Church Hanborough Residents' response to the Applicant's answer to ExQ2.5.5

Q2.5.5	Applicant West Oxfordshire District Council	<p>Land retention at Church Hanborough</p> <p>As noted above, the SoS needs to be satisfied that the land to be acquired is not more than is reasonably required of the purposes of development.</p> <p>Applicant - The ExA notes that land to the southeast of Church Hanborough, Field 2.116 and the northern section of Field 2.115 is contained within the Order limits and is, according to the landscape, ecology and amenity plan [AS-022], available for community food growing.</p> <ol style="list-style-type: none"> 1) What consultation has been undertaken to ensure that this area is the most appropriate for community food growing? 2) If it is not needed or essential to provide space for community food growing, is there a compelling case for compulsory acquisition? 3) What is the actual tangible benefit to the applicant of retaining this land in the Order limits as opposed to re-drawing the boundary to exclude such land entirely? 4) Would the land not be better served being kept in its current agricultural use? 	<p>The land referred to is Field 2.116 and Field 2.117

**Botley West Solar Farm**  
 Historic and Scheduled Sites Plan  
 Sheet 14 of 24

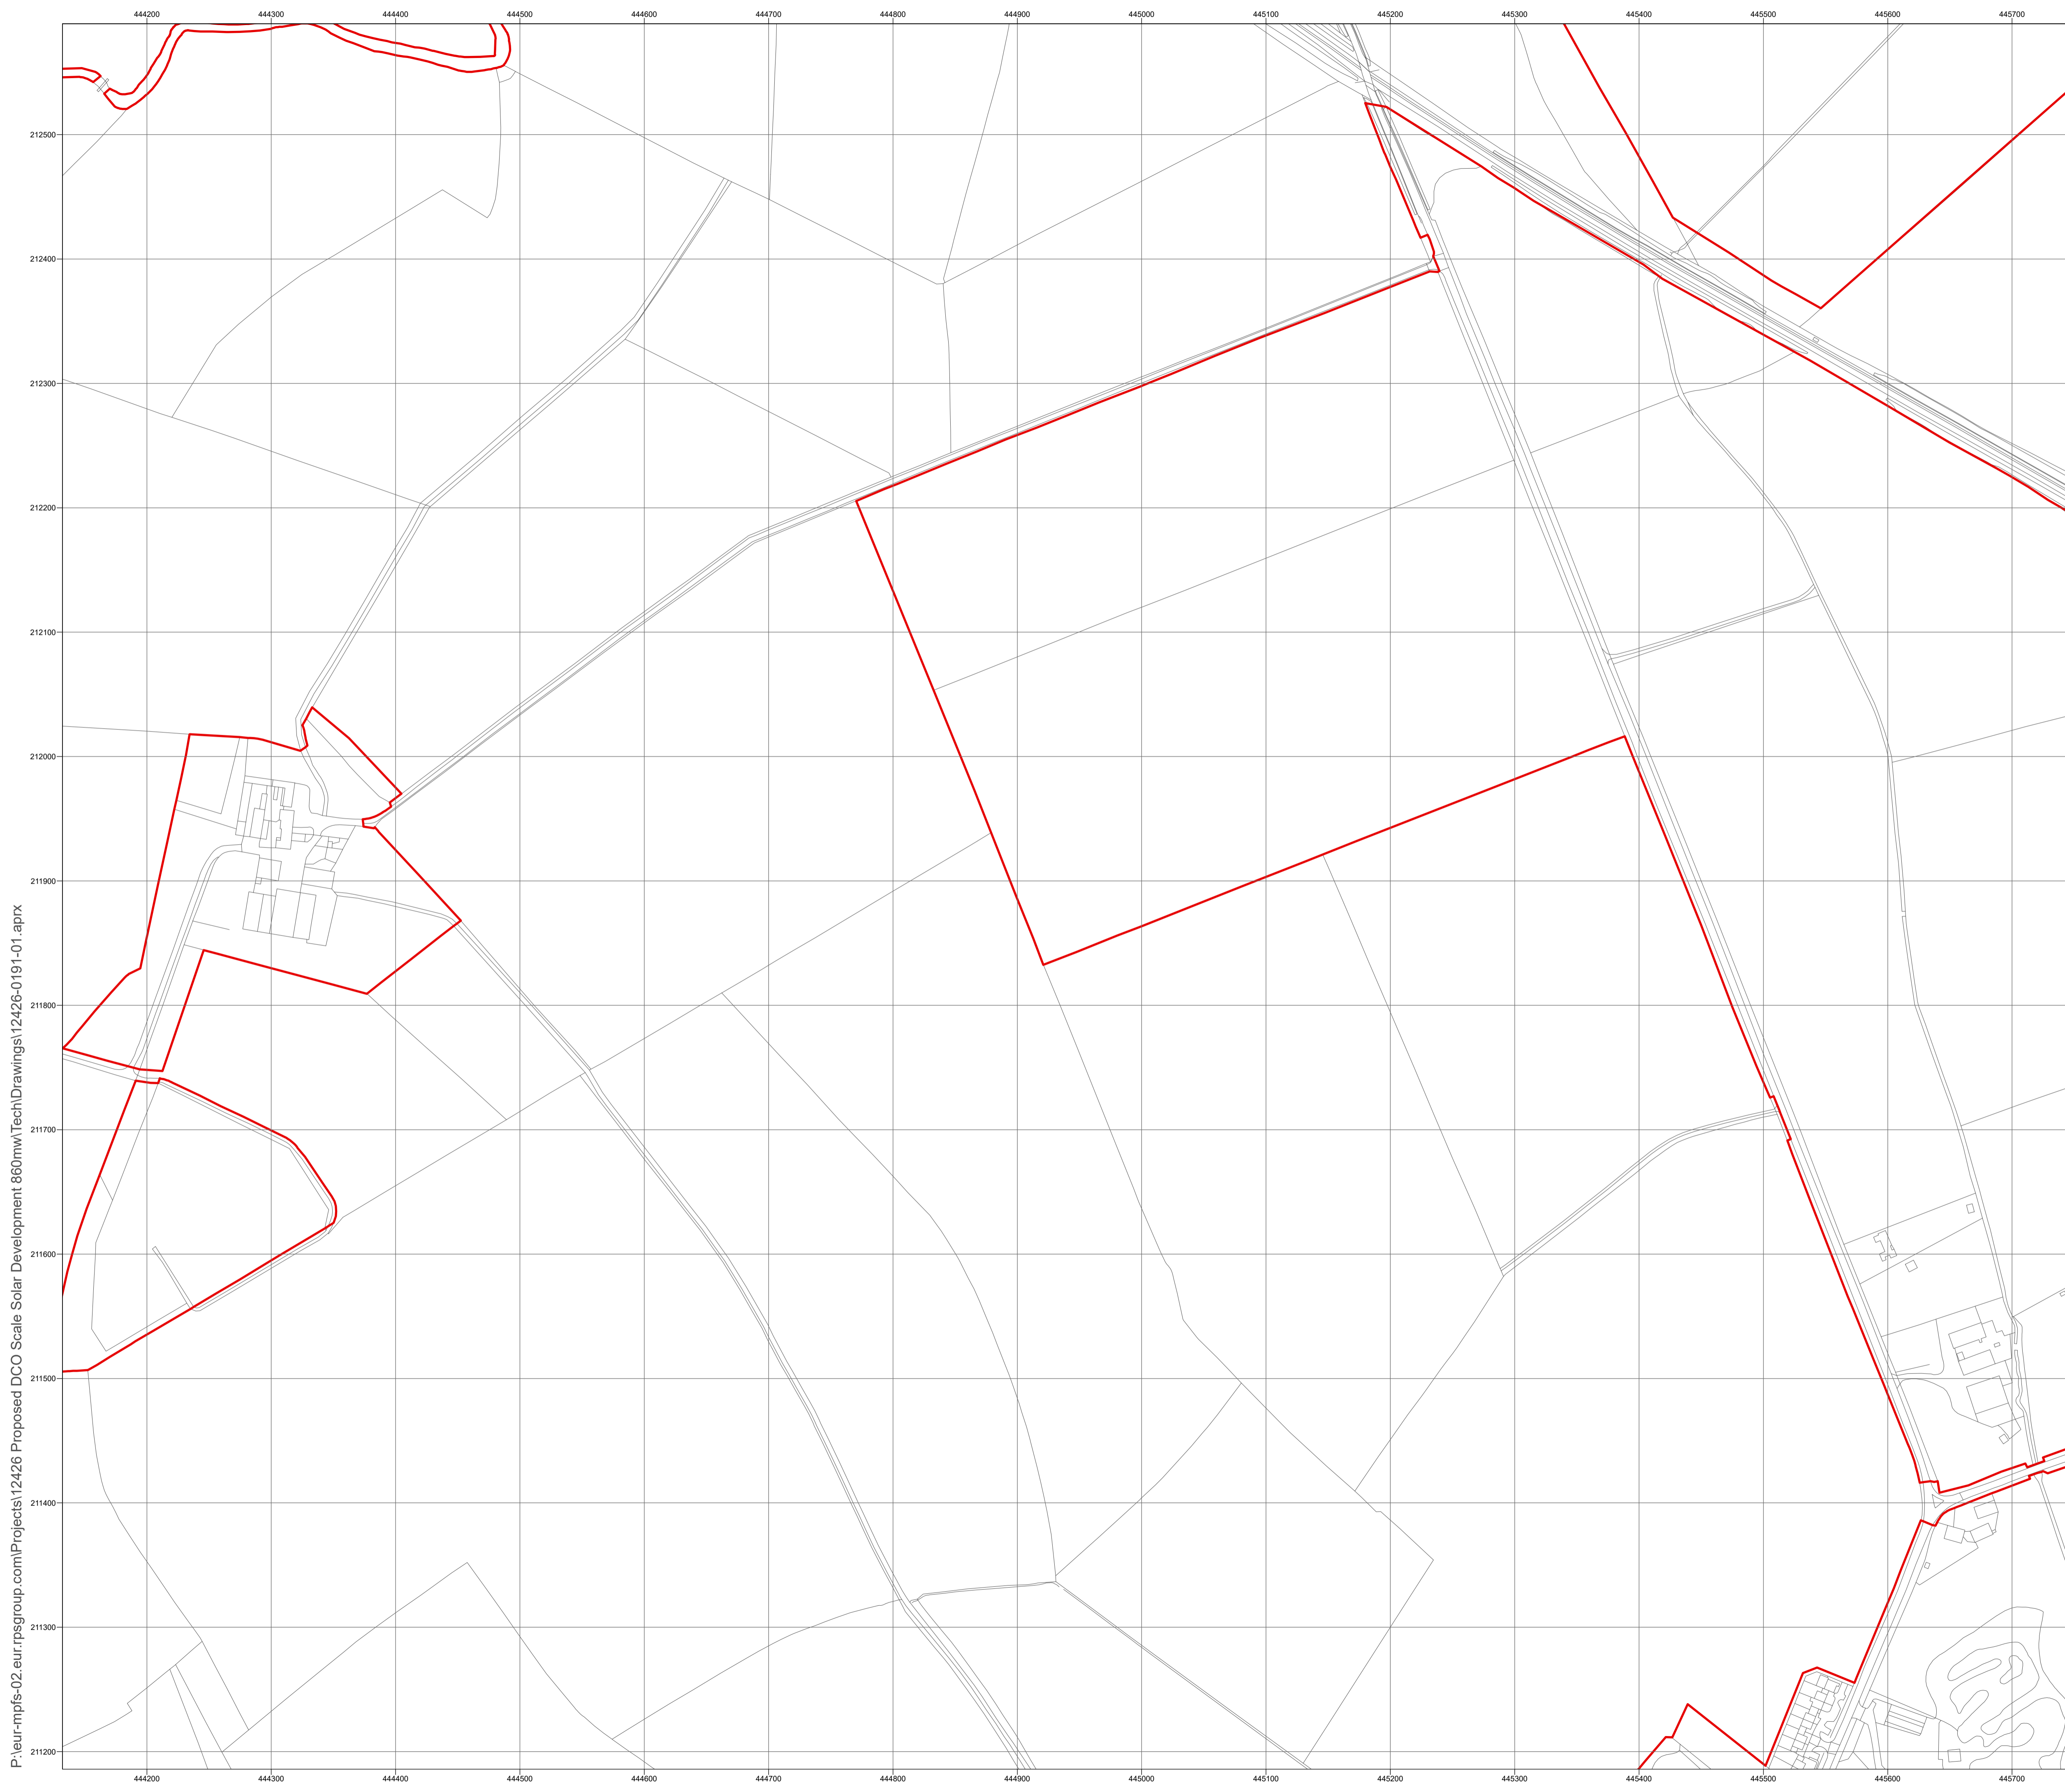
- The land in question is, as ExA states field, 2.116 and the northern part of field 2.115. The Applicant says it is fields 2.116 and 2.117. There is no field 2.117 (ref : APP-131 Appendix 7.1 Historic Environment Desk Based Assessment Figure 2b on page 70)

- The Applicant is wrong to say that *"Panels were removed from these two fields after the Phase One consultation in November 2022 as a result of feedback from residents of Church Hanborough."* In the Phase One Consultation booklet Nov 2022 on pages 12-13 the area of field 2.116 is labelled "Protection of Conservation Area with opportunities for landscape enhancement" there were never any panels planned in field 2.116 (because it is in a conservation area).

1. This field is within a conservation area. It provides a setting for Church Hanborough, the village located at the top of the hill and St Peter's and St Paul Church Spire, which is one of the most beautiful church Spires in Oxfordshire. The field should stay as it is.

2. This field is totally unsuitable for commercial or community food growing. Both need polytunnels, sheds for machinery and tools for produce packaging and distribution. They need to be fenced, and they need access. All these are incompatible with the landscape that needs to 'frame' the conservation area village. As field 2.116 is within the conservation area, any buildings or structures would need special planning permission.

ALL these areas should be removed from the Order Limits.
